RE: Project PR-2019-002496 (Barstow and Alameda NE)

As property owners adjacent to the perimeter of the proposed Monet Apartment Project, we OBJECT to this project as designed. The facts of this matter are as follows:

1 Site Plan - West
1" = 20'-0"

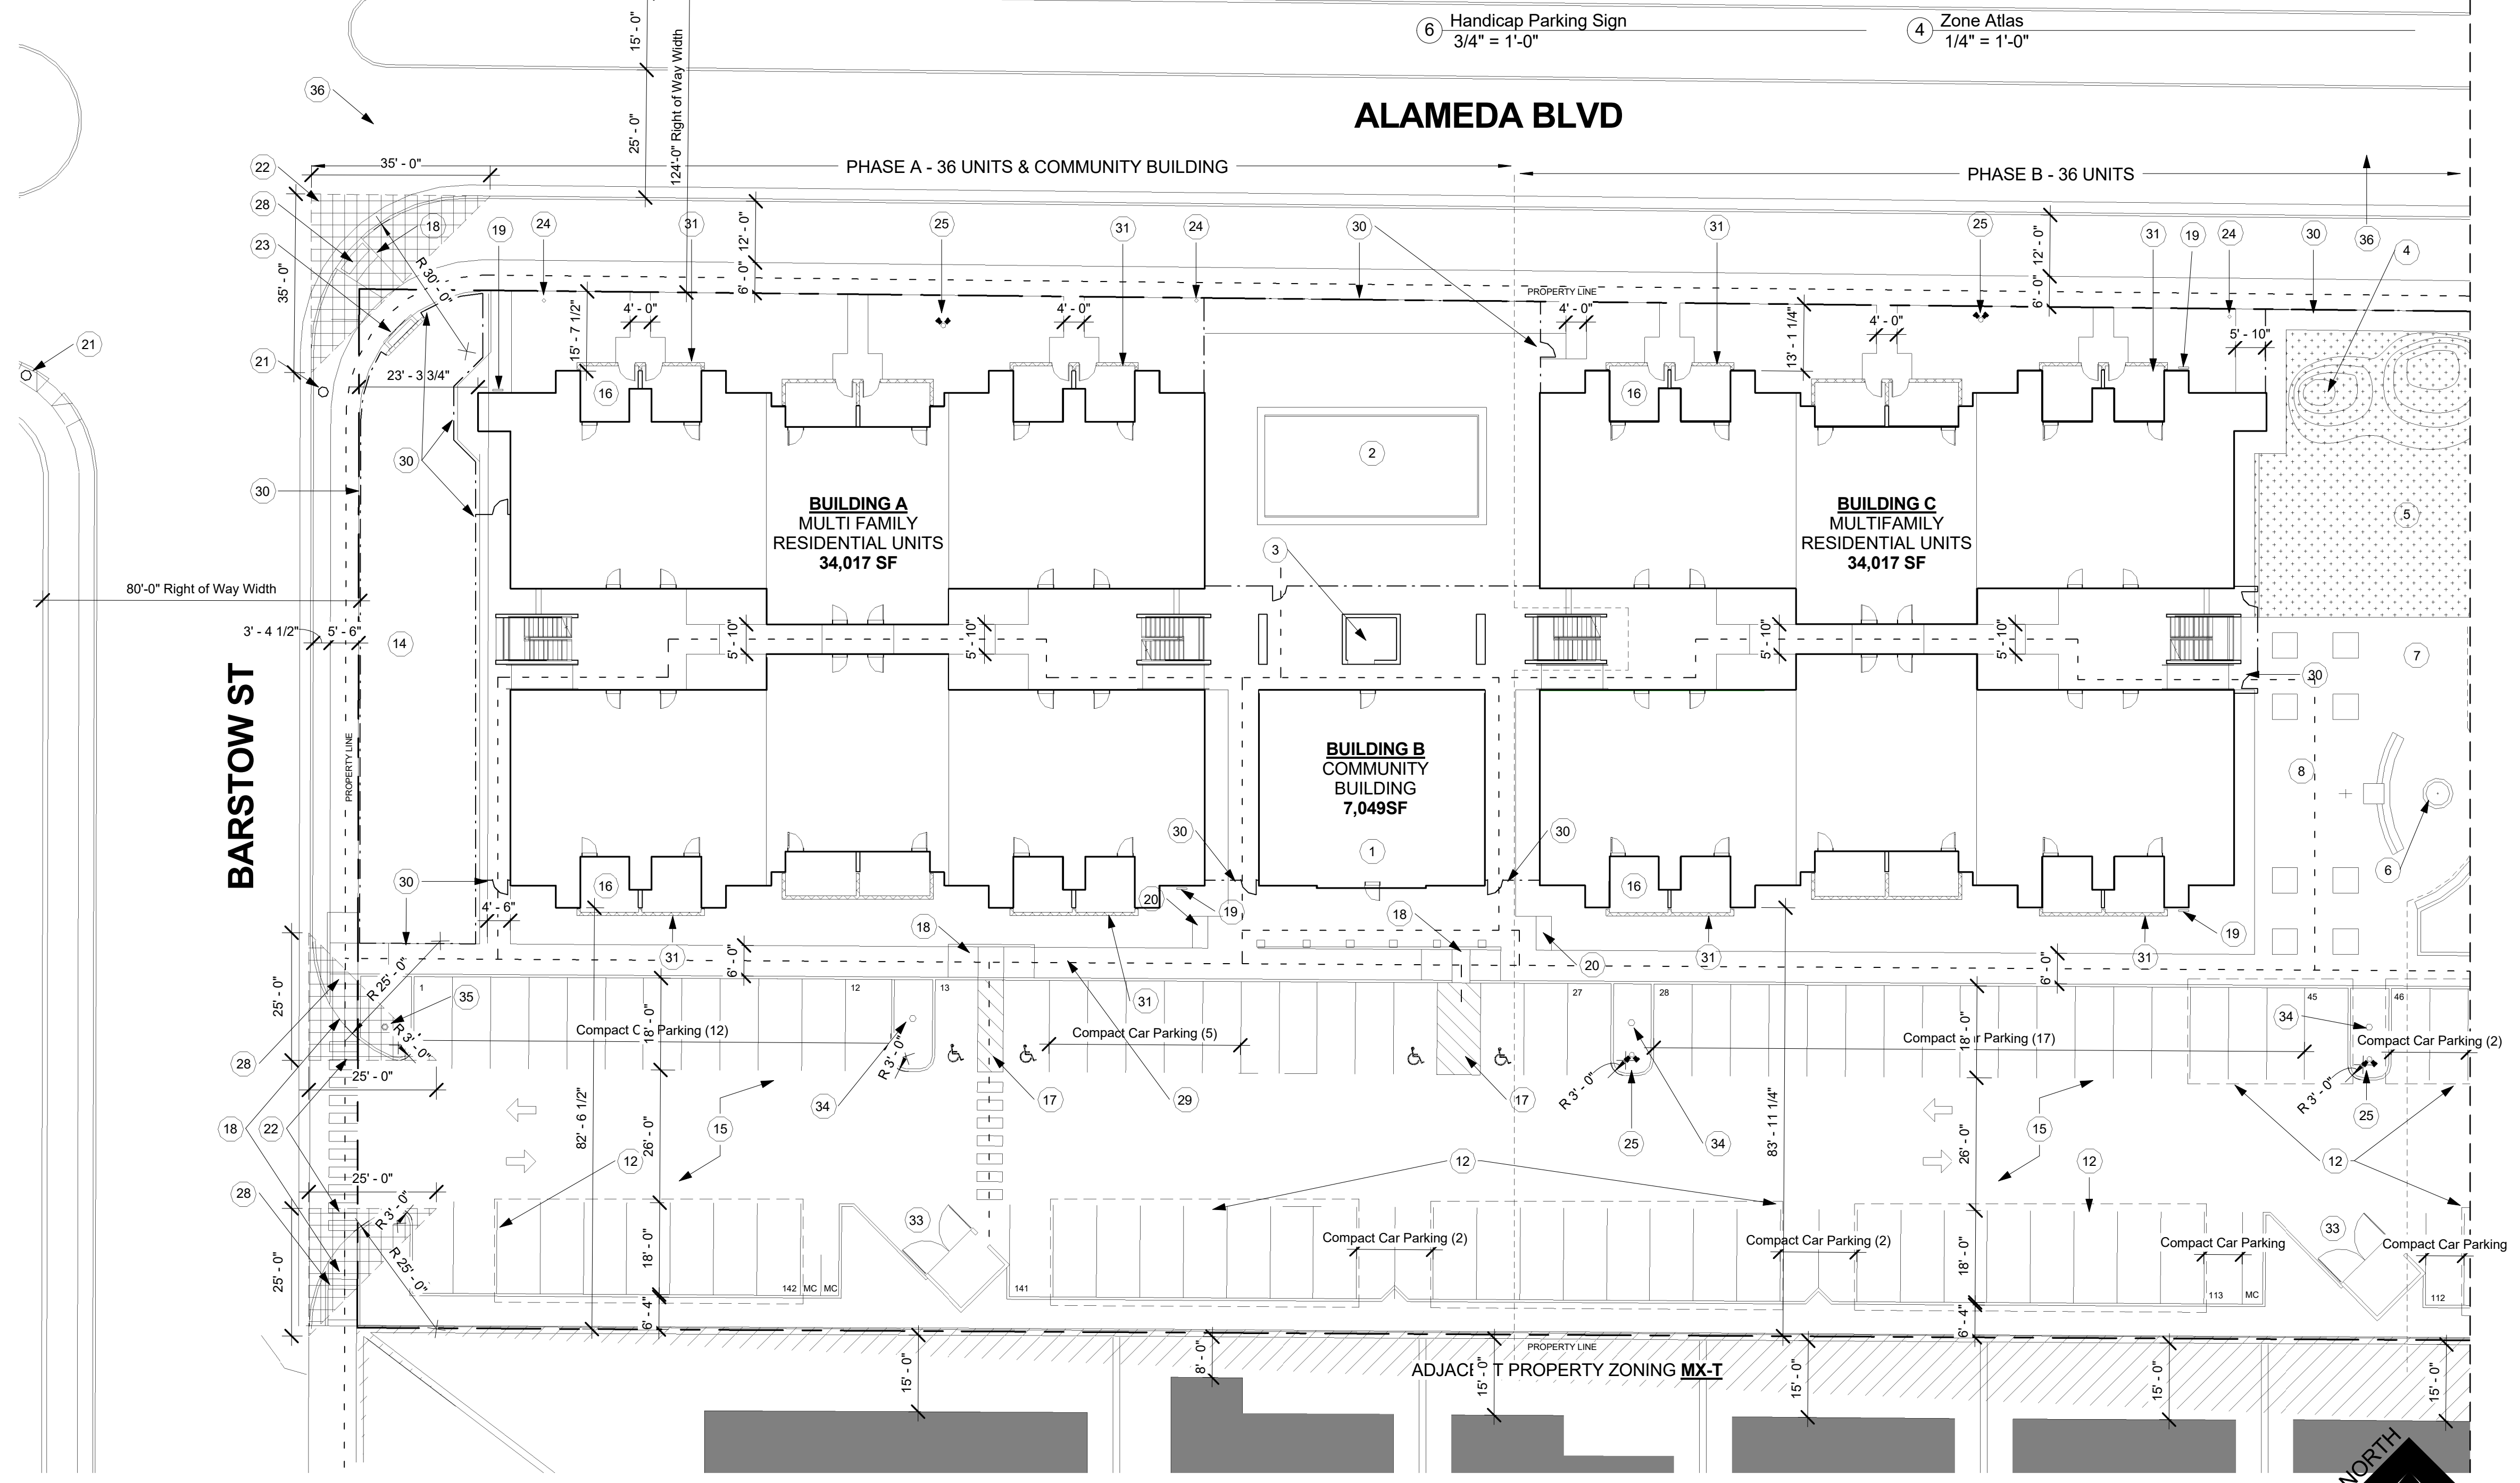
- Using the Site plan drawings of the sidewalk and median across Barstow to the west as a reference, the distance of the section indicated on the drawing as a 124-foot “Right of Way” width is actually closer to 88 feet (Site Plan Drawings p. 1, labeled “Sheet no: DRBI.O”).
- The Site Plan drawings indicate that sidewalks will not line up and the new buildings will protrude forward by 20 feet. Whereas with an accurate 124-foot “Right of Way” measurement, the sidewalks and buildings would line up with the adjacent properties. (See Figure 8, 9)

② Phase C-West
1/8" = 1'-0"

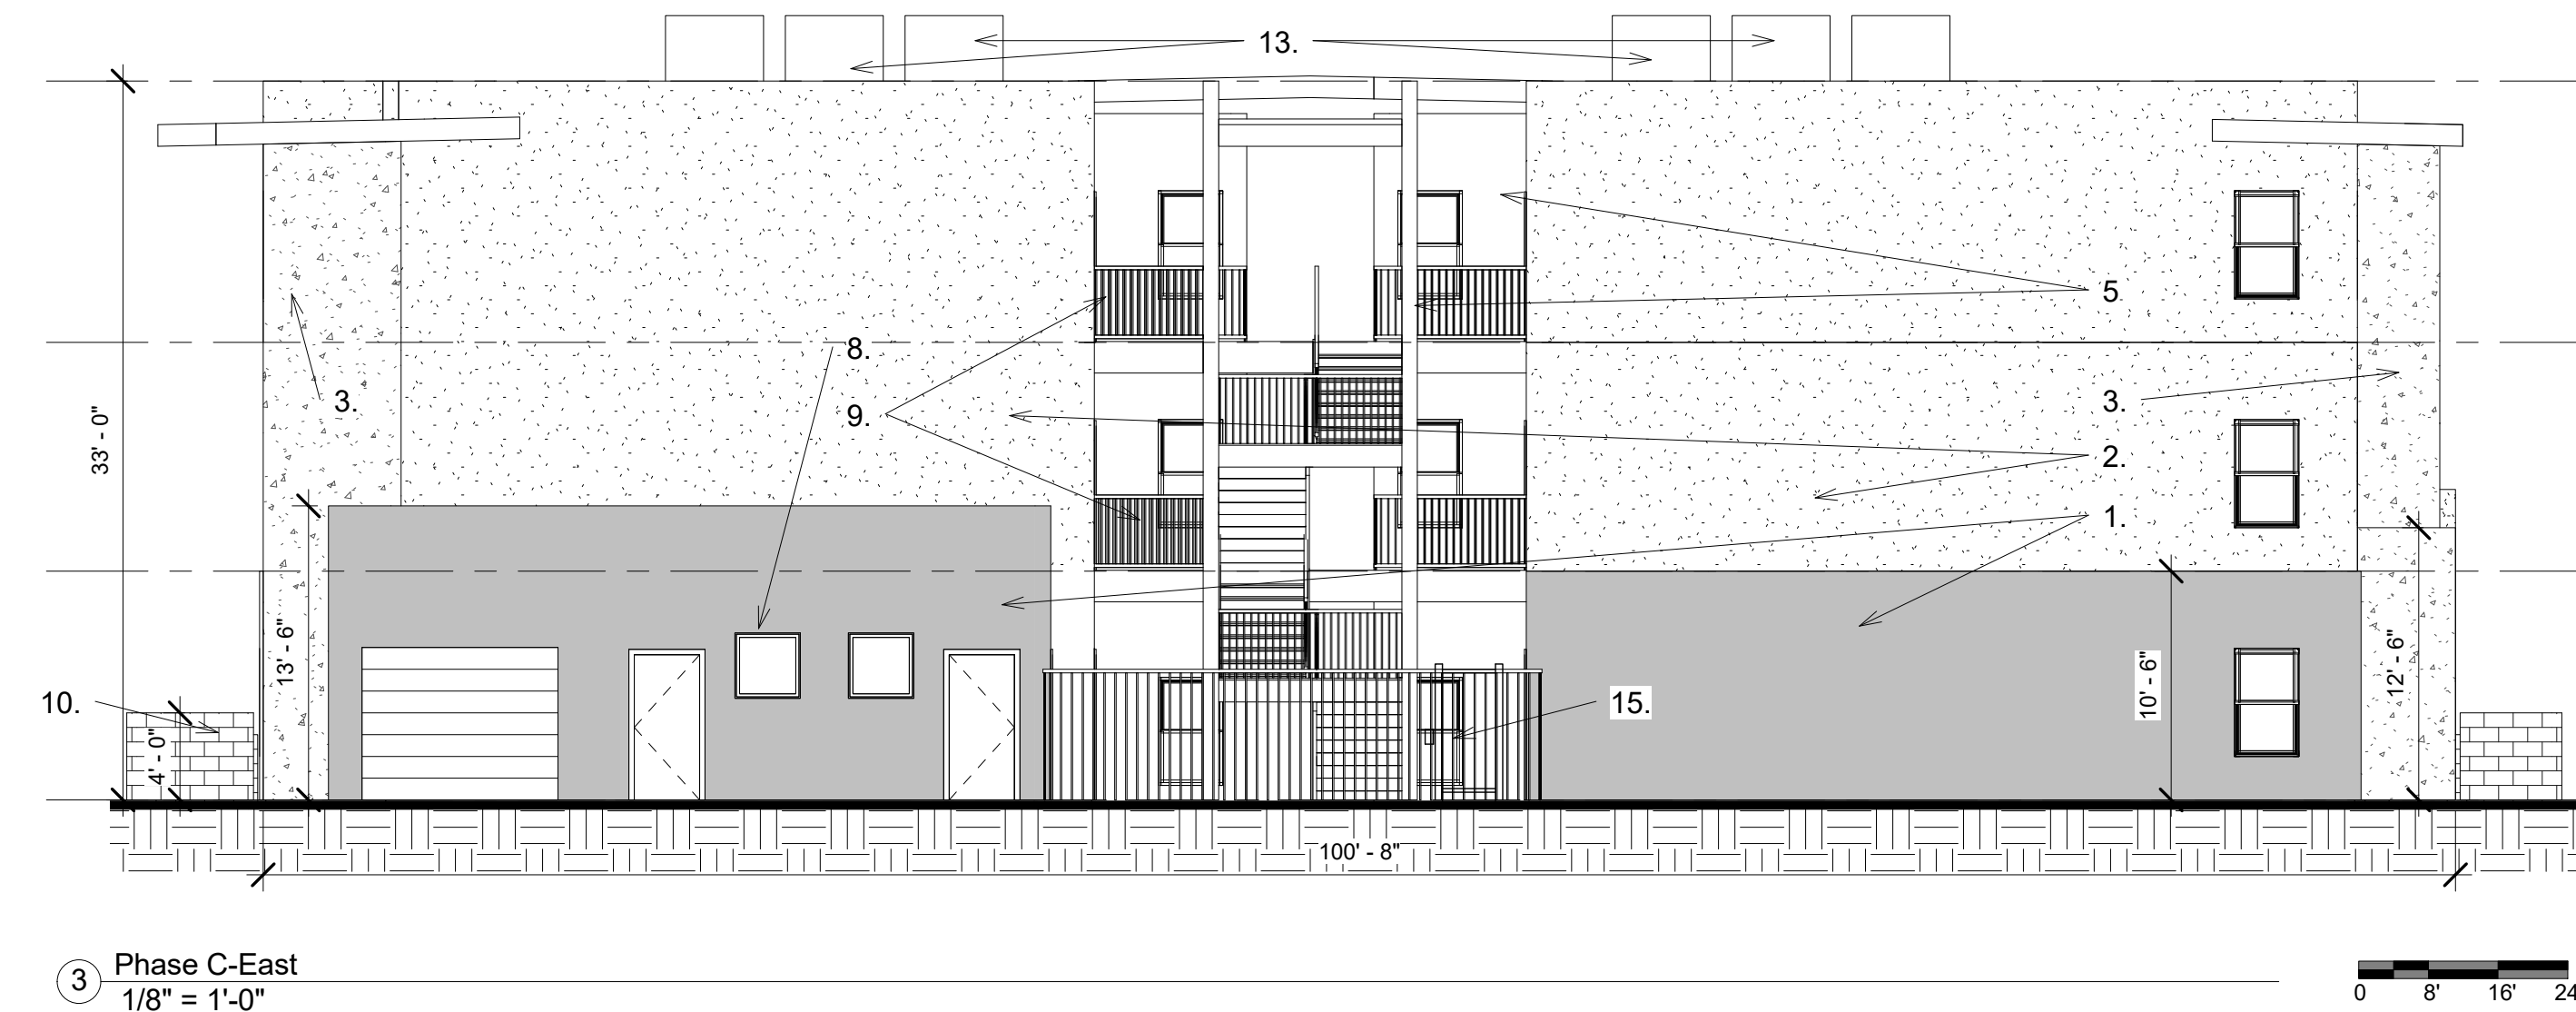
- Facilitated meeting reports document many such consistency-related concerns raised by members of the neighborhood: density, three-story height, 38-foot elevator shaft, and bright stucco colors not consistent with neutrals of the area, including an entire building side designated to be Red-Orange (Phase C – West, rendering and Site Plan Sheet 7).
